Our ref: DOC24/595664
Your ref: SSD-63207219

Kingswood Battery Energy Storage System – Exhibition of EIS

Thank you for your request via the NSW Planning Portal dated 17 July 2024 to the Biodiversity, Conservation and Science Group (BCS) of the NSW Department of Climate Change, Energy, the Environment and Water (NSW DCCEEW) inviting comments on the exhibited Environmental Impact Statement (EIS) for the Kingswood Battery Energy Storage System (BESS).

Figure 3-3: Vegetation survey effort and ground-truthed vegetation

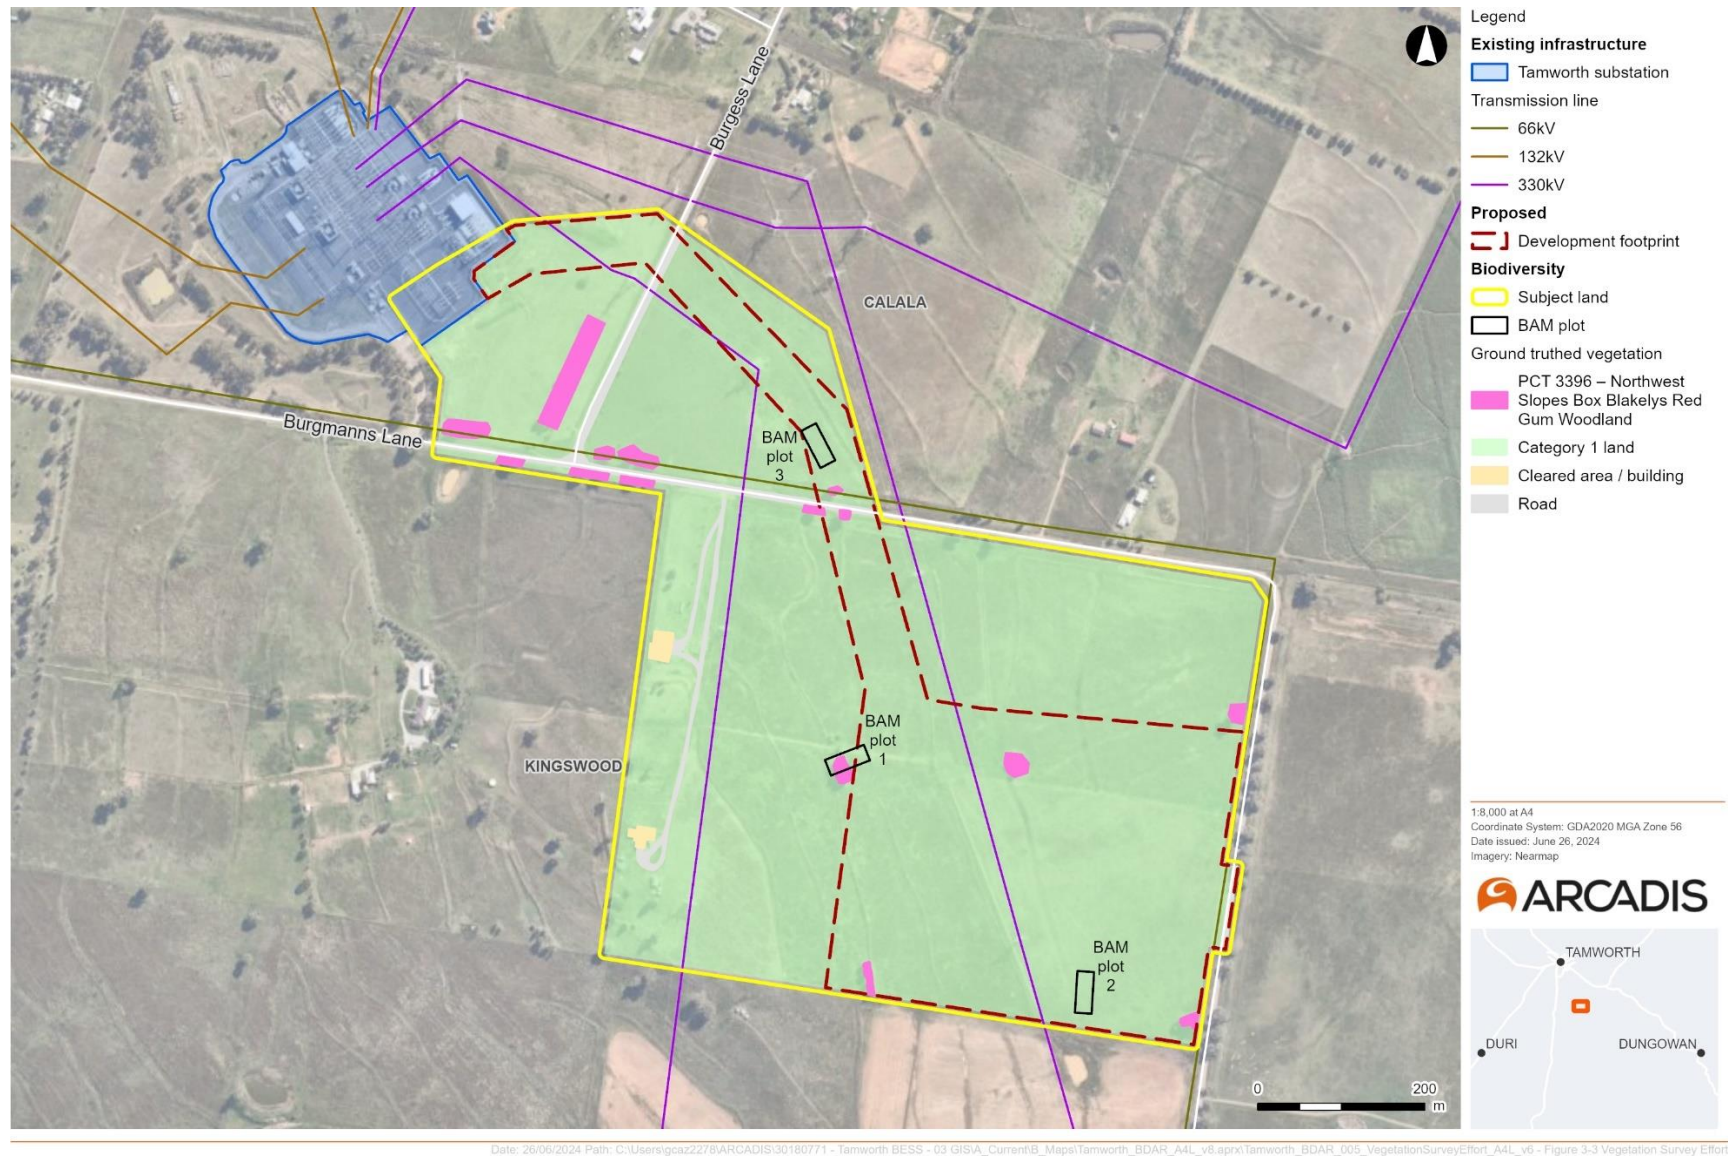
3. The subject land north of Burgmann's Lane has been mapped as Category 2 in the draft Native Vegetation Regulatory (NVR) map. Figure 3-3 of the BDAR does not align with the draft NVR map. One BAM plot is located north of Burgmann's Lane; however, as the three BAM plots shown in Figure 3-3 are labelled differently to the BAM-C case, we are unable to verify which of the BAM plot sheets relate to this plot. In this instance the vegetation integrity scores for the BAM plots in this vegetation zone are extremely low and do not generate ecosystem credits; therefore, this issue is inconsequential to determining the project credit calculation. The AA must ensure that in future BDARs a full justification of land classified as Category 1, particularly where this differs from the draft NVR map, be provided and that BAM plots are easily identifiable between the BDAR and BAM-C case.

However, Tables Table 3-3 and 3-4 of the BDAR describe the vegetation zones as “vegetation zones 3396_low” and “Category 1 land”. These are depicted in Figure 3-3 although the vegetation zones are not labelled appropriately.

As the three BAM plots shown in Figure 3-3 are labelled differently to the BAM-C case BCS has been unable to verify the locations of all 3 BAM-C plots.

- 2.1 Update the BDAR to justify the vegetation zones.
- 2.2 Update Figure 3-3 to clearly delineate the vegetation zones.
- 2.3 Ensure that vegetation zones in the BDAR are consistent with those in the BAM-C.

- 3.1 Revise Figure 3-3 to ensure consistent labelling of the BAM plots.
- 3.2 Provide all field data corresponding to each BAM-C plot, with consistent labels and data on plot locations.
